# Stonestreet Green Solar

## Signed Statement of Common Ground with the Environment Agency

Doc Ref. 8.3.2(B)

January 2025

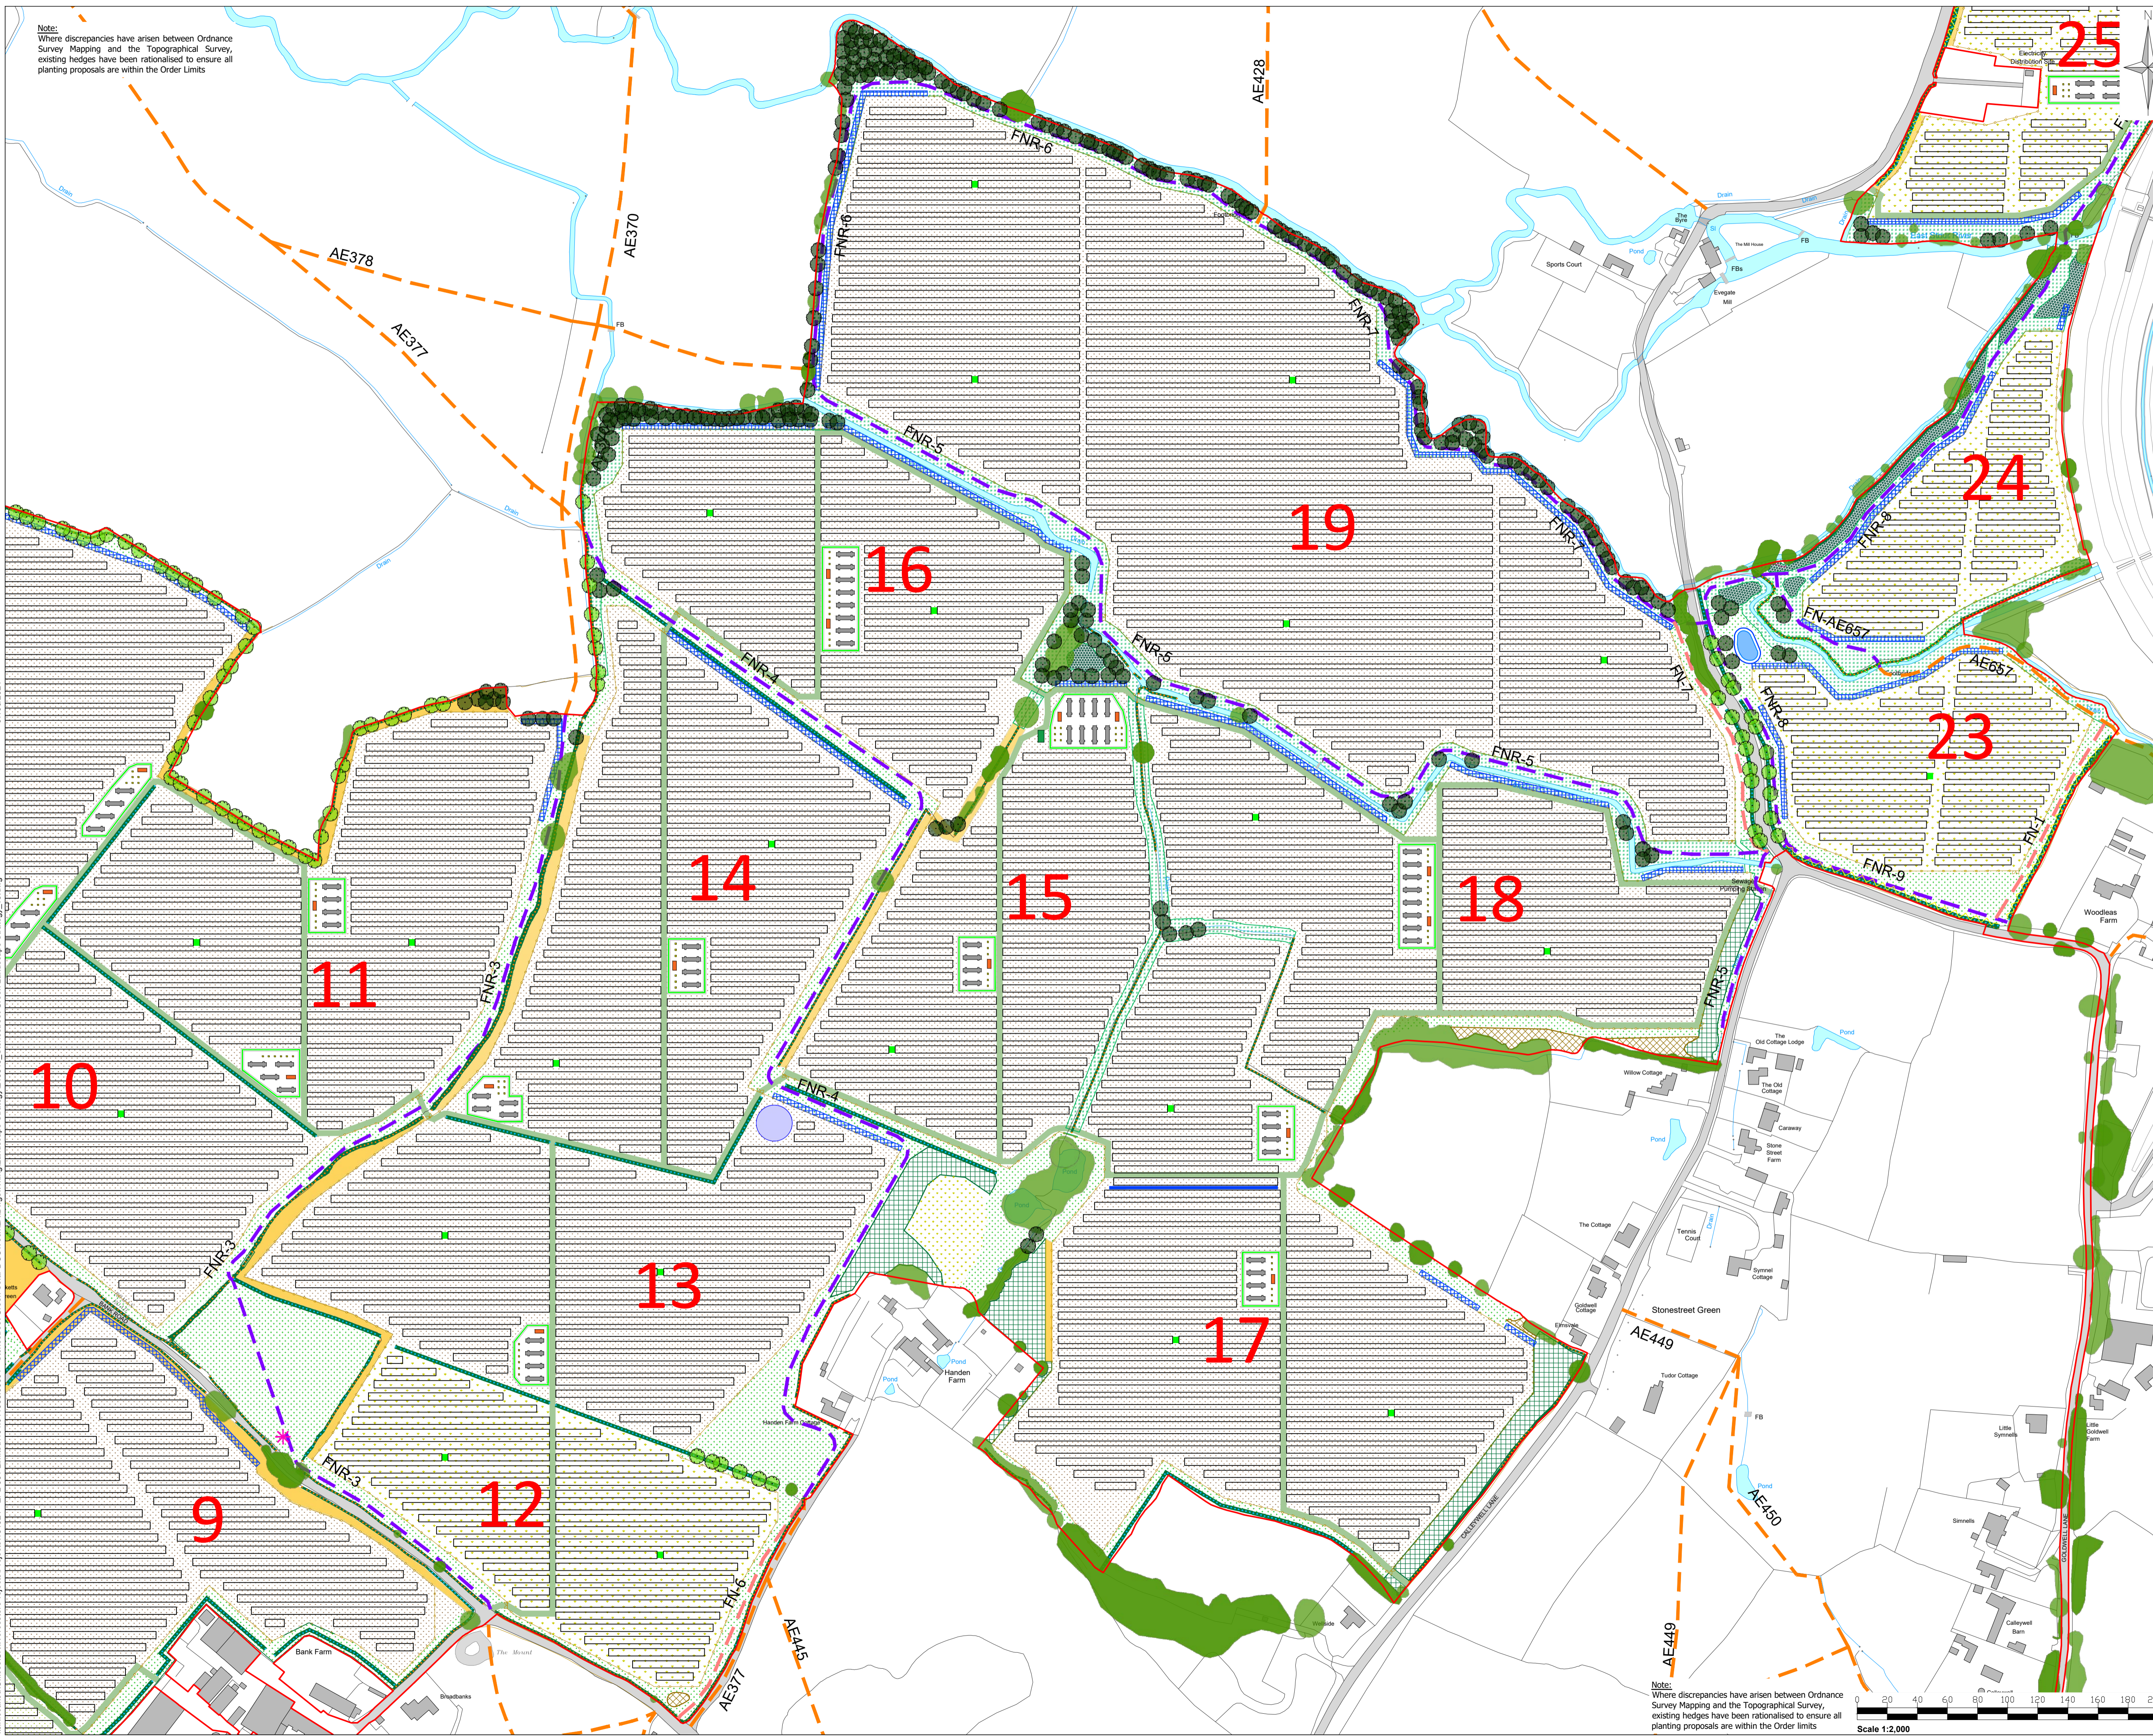
Ref	Relevant Application Document	Description of Matter	EA Current Position	Applicant's Current Position	Status
2.10 to 12	RR	Issue 3 - Flood Storage Calculations	<p><b>Situation:</b> The 'Floodplain Compensation level for Level Calculation' table from 'Annex D: Floodplain Compensation Level for Level Calculations' of the FRA demonstrates a net increase (1,543.11 m3) in flood storage downstream of the Aldington Flood Storage Area but does not show any net increase within Aldington Flood Storage Area as referenced in the Outline Operational Surface Water Drainage Strategy (OOSWDS). Paragraph 5.1.5 of the OOSWDS states "The swale and wetland areas have both been designed to enhance biodiversity and ensure that there is no adverse impact on water quality. In addition, the wetland area, which will be sited within the AFSA, will increase the capacity of fluvial flood storage available. This will therefore contribute to a small reduction in downstream flood risk." (<i>APP-094 – Doc 5.4 Environmental Assessment Appendix 10.2: Flood Risk Assessment; APP-159 – Doc 7.14</i>)</p>	<p>None of the works proposed within the AFSA involve any build up in ground levels.</p> <p>The works proposed relate to;</p> <ol style="list-style-type: none"> <li>1. Superficial treatments and vegetation management with a commitment made that vegetation management will be ongoing with any accumulated material removed from the AFSA. Such work would therefore have a neutral impact on flood storage,</li> <li>2. The provision of fencing around the skylark area in Field 29 as illustrated on the <b>Illustrative Landscape Drawings (Doc Ref. 2.7(B))</b> (Sheet 3 of 5 - drawing number 011998.00001.712). The fence posts would result in a negligible loss of flood storage, but at a level that would be difficult to quantify.</li> <li>3. The creation of ecological scrapes and ponds as illustrated on the <b>Illustrative Landscape Drawings (Doc Ref. 2.7(B))</b> (Sheet 3 of 5 - drawing number 011998.00001.712). These would</li> </ol>	Agreed

Ref	Relevant Application Document	Description of Matter	EA Current Position	Applicant's Current Position	Status
			<p><i>Outline Operational Surface Water Drainage Strategy</i>)</p> <p><b>Impact:</b> The storage capacity of Aldington Flood Storage Area may be reduced by the proposed landscaping works.</p> <p><b>Solution:</b> The applicant should amend the flood storage calculations within the 'Floodplain Compensation level for Level Calculation' table from 'Annex D: Floodplain Compensation Level for Level Calculations' of the FRA to show the flood storage increase inside Aldington Flood Storage Area as stated in the paragraph 5.1.5 of the OOSWDS "increase the capacity of fluvial flood storage available".</p> <p>22/11/2024 (EA) As outlined above when the <b>Outline OSWDS (Doc Ref. 7.14)</b> is updated to include that there will be no net loss of storage capacity within the AFSA this will be conditioned. We have no further comments to make until we have reviewed the requested supporting calculations and updates to <b>Environmental Statement</b></p>	<p>be formed by excavation only with all spoil removed disposed of outside of the AFSA. As such these works would only increase the available flood storage volume.</p> <p>4. The creation of the wetland area which will receive storm runoff from the Project Substation. This will be formed by excavation and will not involve impounding water to a level above the existing ground surfaces. As such the formation of this feature can only increase the volume of flood storage available.</p> <p>The net effect of these works will clearly be an increase in the available flood storage volume within the AFSA. On this basis no further assessment was deemed necessary.</p> <p>In response to this comment work is however now being undertaken to quantify the changes resulting from items 2, 3 and 4 above. This additional detail will be included within <b>ES Appendix 10.2: Flood Risk Assessment (Doc Ref 5.4(A))</b> <a href="#">[REP1-036]</a> <a href="#">[REP1-037]</a> and <a href="#">[REP1-</a></p>

Ref	Relevant Application Document	Description of Matter	EA Current Position	Applicant's Current Position	Status
			<p><b>Appendix 10.2: Flood Risk Assessment (Doc Ref 5.4).</b></p> <p>16/01/2025 (EA) We have reviewed the updated Outline OSWDS (Doc Ref. 7.14(A)) dated December 2024 which now includes commitment in section 4.6.8 that the Project would not result in a net loss of storage capacity with the AFSA.</p> <p>Section 4.6.8 of the Outline OSWDS states "The wetland area also provides the benefit of creating additional storage within the Aldington Flood Storage Area. This effect is quantified in ES Volume 4, Appendix 10.2: Flood Risk Assessment (Doc Ref. 5.4). The final detailed design for this feature, and other small ecological ponds and scrapes, will ensure that there is a net increase in flood storage provided within the Aldington Flood Storage Area." We are satisfied with the changes to the Outline OSWDS.</p>	<p><a href="#">038</a>]. The updated document will be provided by Deadline 1.</p> <p>In addition, the Applicant will also amend the <b>Outline OSWDS (Doc Ref. 7.14(B))</b> to include a commitment to ensure no net loss of storage capacity within the AFSA.</p> <p>The Applicant awaits the EA's confirmation that the updates to the <b>Outline OSWDS (Doc Ref. 7.14(B))</b> are acceptable.</p>

Ref	Relevant Application Document	Description of Matter	EA Current Position	Applicant's Current Position	Status
			<p>Additionally, we have reviewed the updated Flood Risk Assessment (FRA) (Doc Ref. 5.4(A)) dated December 2024 which now includes level for level flood storage calculations for the land upstream of the AFSA embankment shown in Appendix D 'Upstream of AFSA Embankment: Floodplain Compensation Level for Level Calculations'. Section 11.3.9 of the FRA states "flood storage is increased within the ASFA by 1,684m3." We are satisfied that the FRA now shows a net increase in flood storage capacity within Aldington Flood Storage Area.</p> <p>We note that the Environment Agency has been added as a statutory consultee for the approval of the Detailed OSWDS secured by Requirement 11 of the Draft DCO (Doc Ref. 3.1(C)) which we are satisfied with.</p> <p>Status changed to "Agreed".</p>
